From: Neil Martin
Sent: 11 July 2012 09:16
To: Graeme Thorpe
Subject: RE: RE - 3/2012/0557/P

From: Graeme Thorpe
Sent: 10 July 2012 12:36
To: Neil Martin
Subject: RE - 3/2012/0557/P

Could you have a look at the above application and give me your feedback on the proposed air source heat pumps they wish to install. A nearby neighbour is raising concerns over their noise.

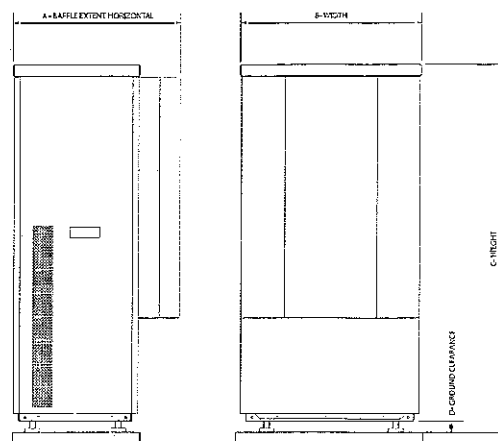
I've had a quick look at this, and while I can't find the heat pump details on-line anywhere, the specifications given with the application give a noise level of 68dB

It is unclear whether this is a, c or z weighted but I'm presuming A weighted. No information is given over low frequency noise from the kit m but distance calculations will give a sound level on the boundary of just over 30dB, and would therefore be acceptable at the nearest property.
